SEGMENTS 9a, 9b and 12 WATER SYSTEM IMPROVEMENTS CASCADE METROPOLITAN DISTRICT NO. 1

EROSION CONTROL PLAN - SEGMENT 8a & NOTES
WATER SYSTEM IMPROVEMENTS
CASCADE METROPOLITAN DISTRICT NO. 1

EROSION CONTROL PLAN - SEGMENT 7b
WATER SYSTEM IMPROVEMENTS
CASCADE METROPOLITAN DISTRICT NO. 1

A PROFILE - SEGMENT 8a  
 12 SCALE: 1" = 30' HORIZ., 1" = 5' VERT.

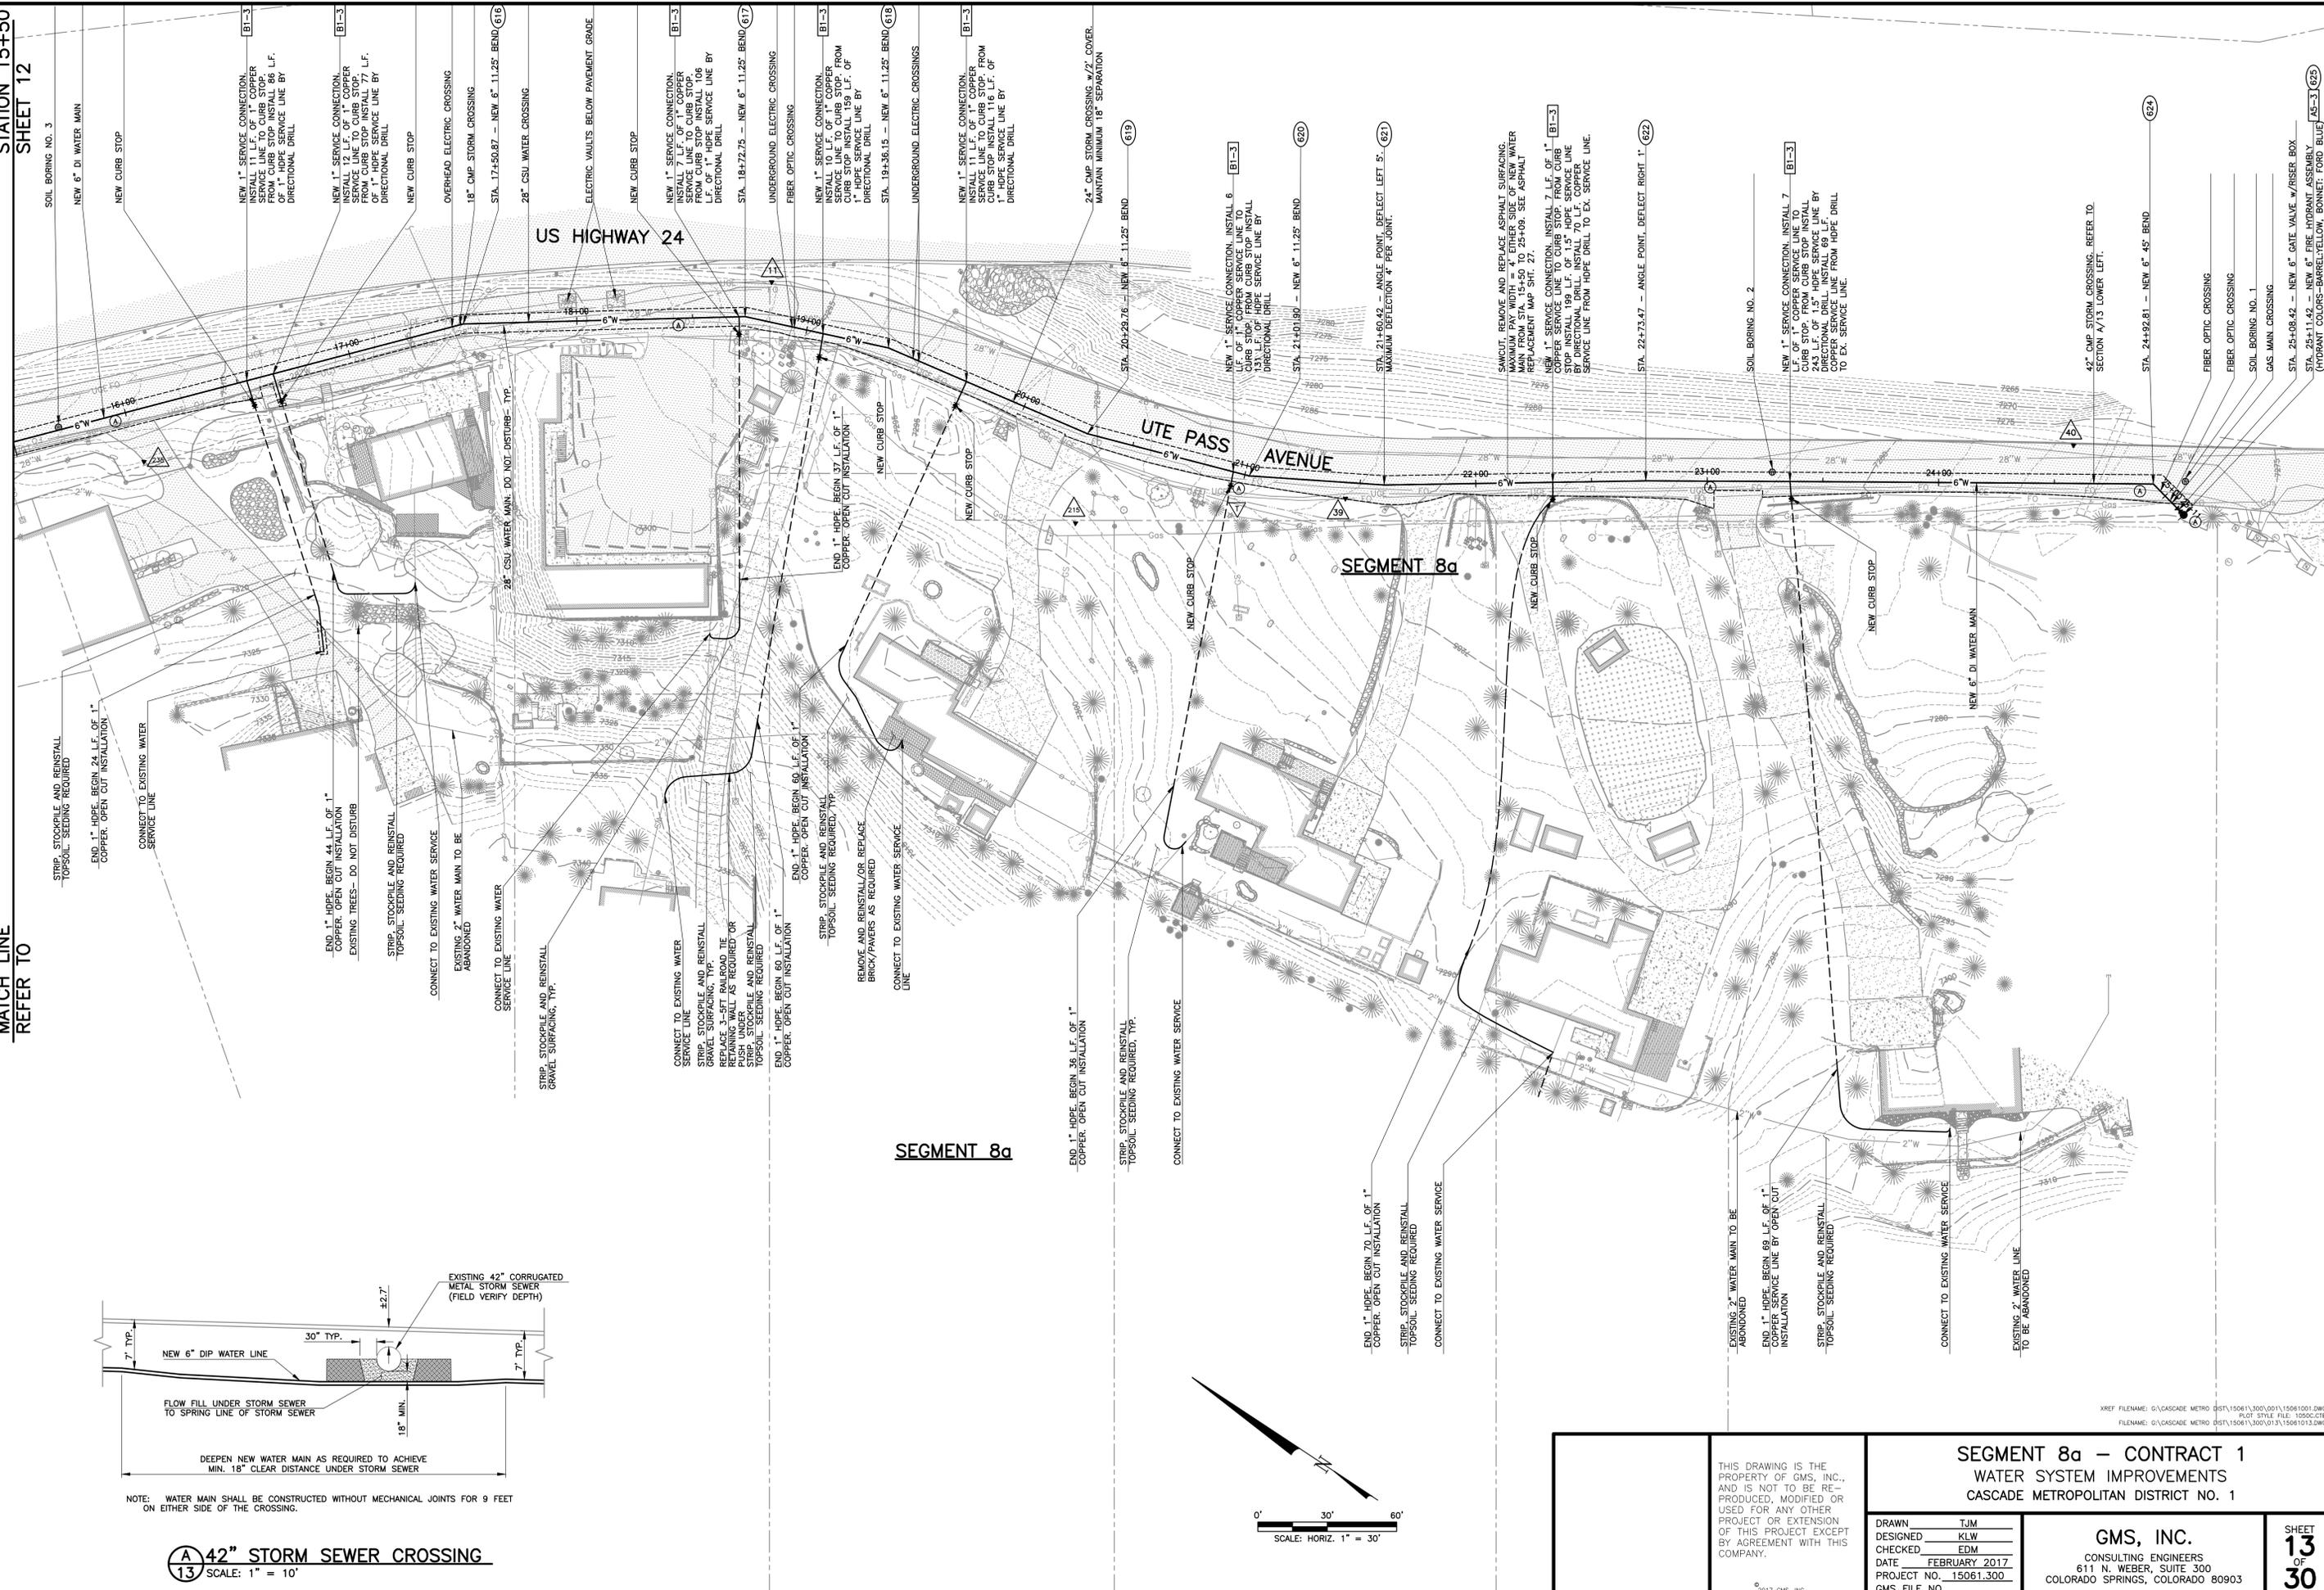
Show excavation(s) for crossing and trench detail if open cut.

Is this bore or open cut?
SEE PROFILE BELOW.

**SEGMENTS 3c AND 7b - CONTRACT 1**  
**WATER SYSTEM IMPROVEMENTS**  
**CASCADE METROPOLITAN DISTRICT NO. 1**

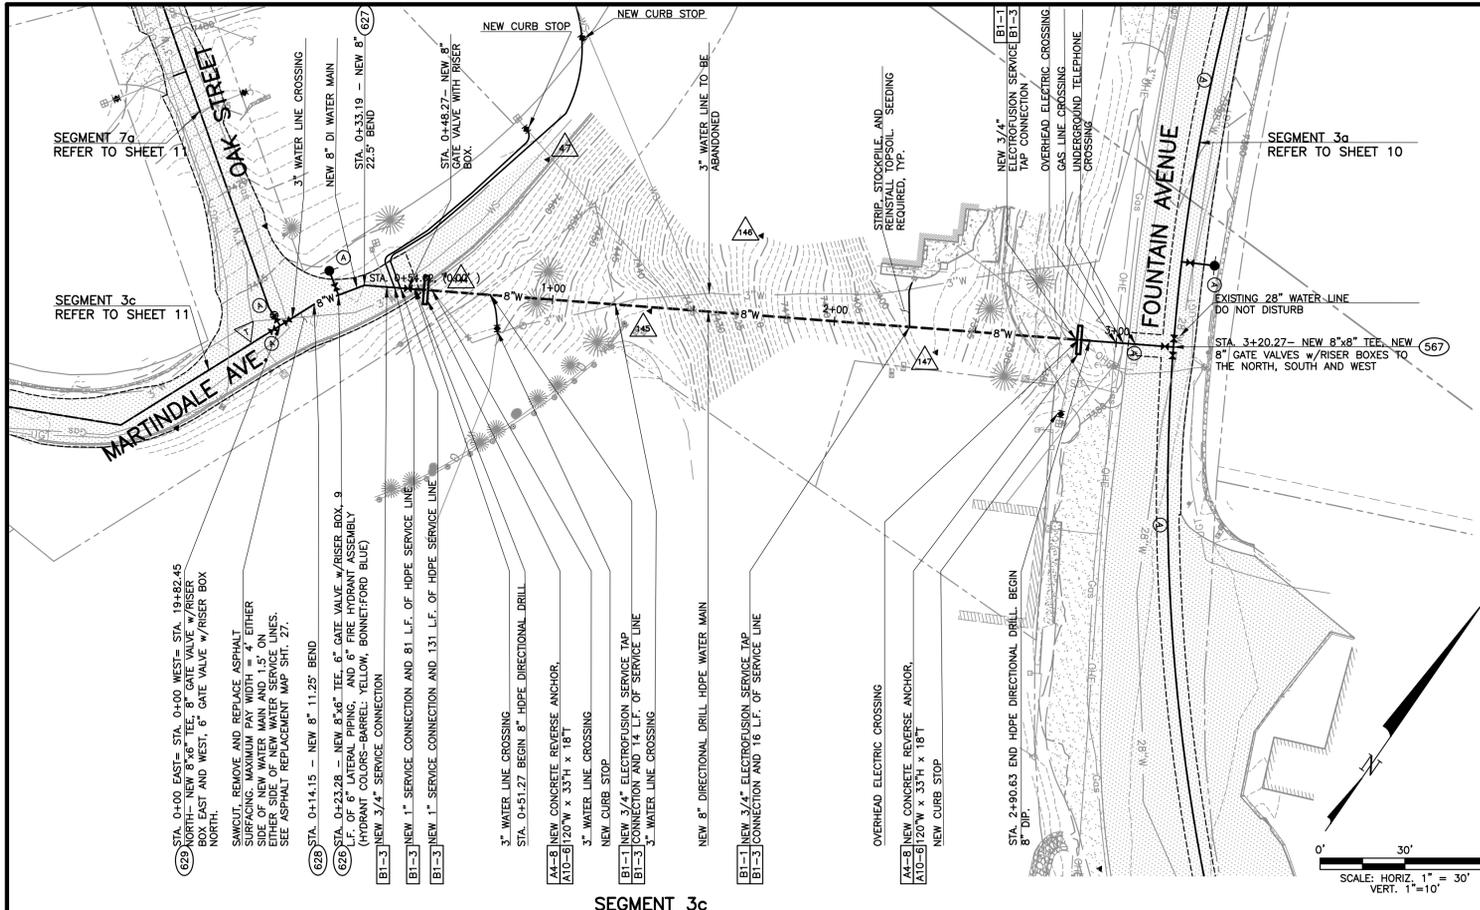
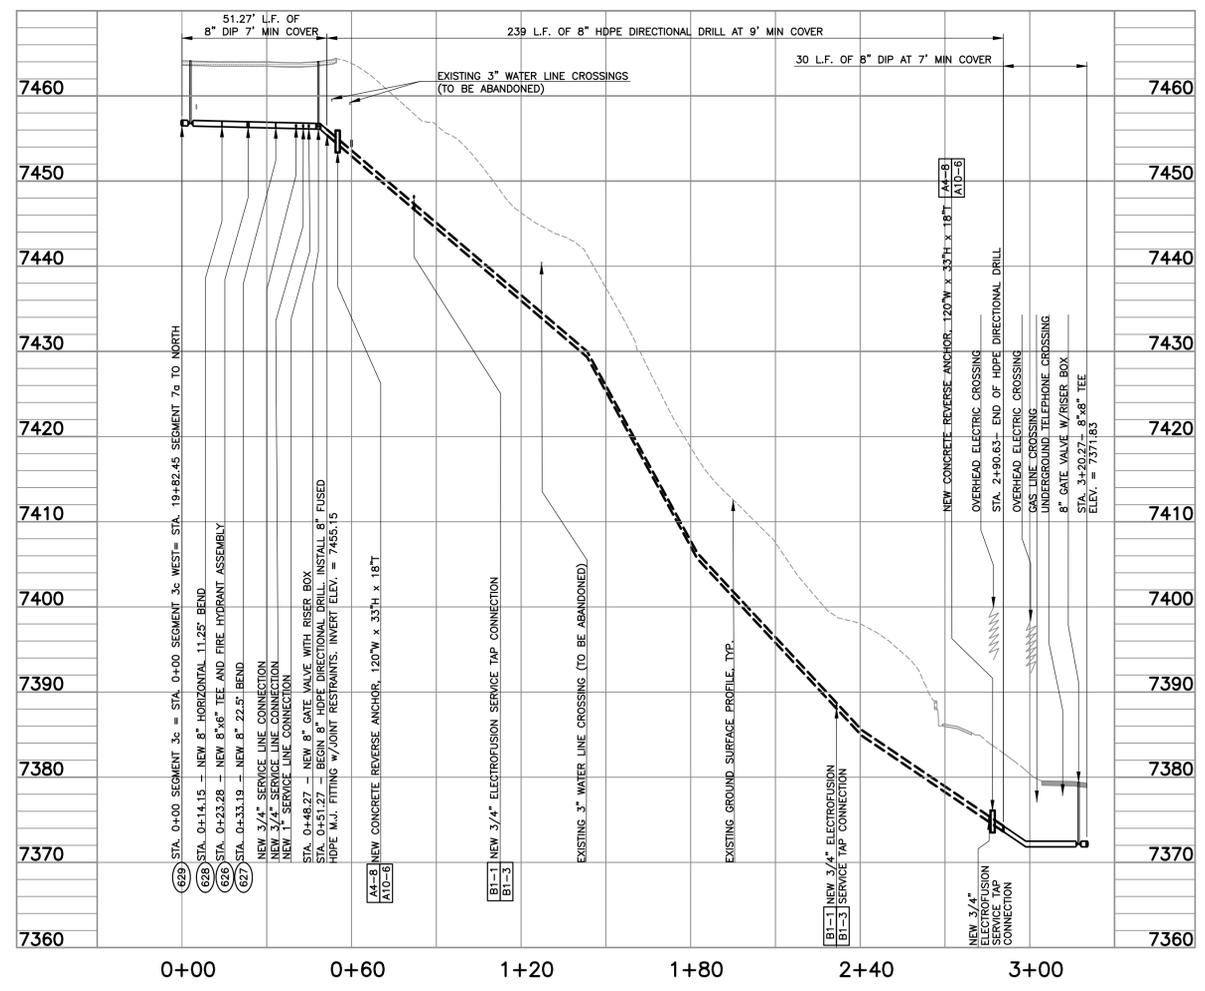
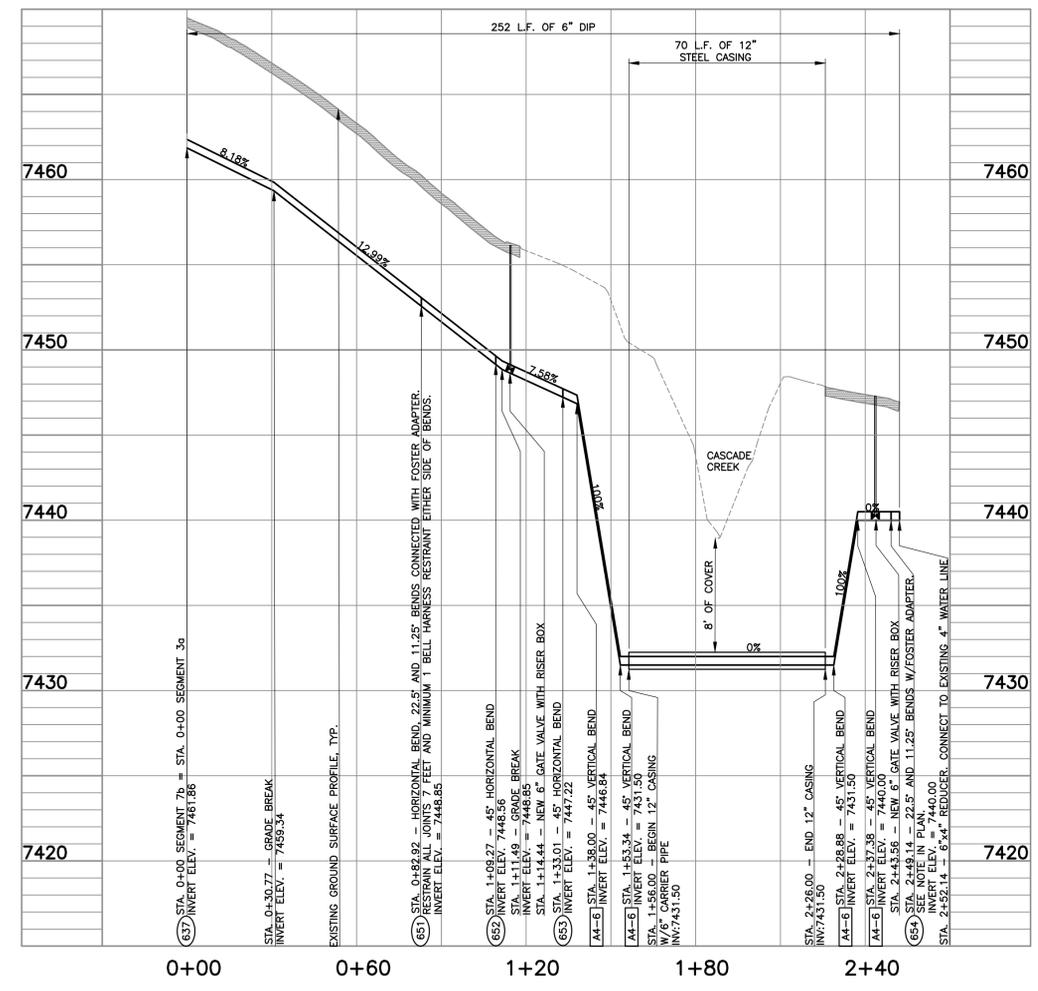
Provide sheet 21 in SWMP
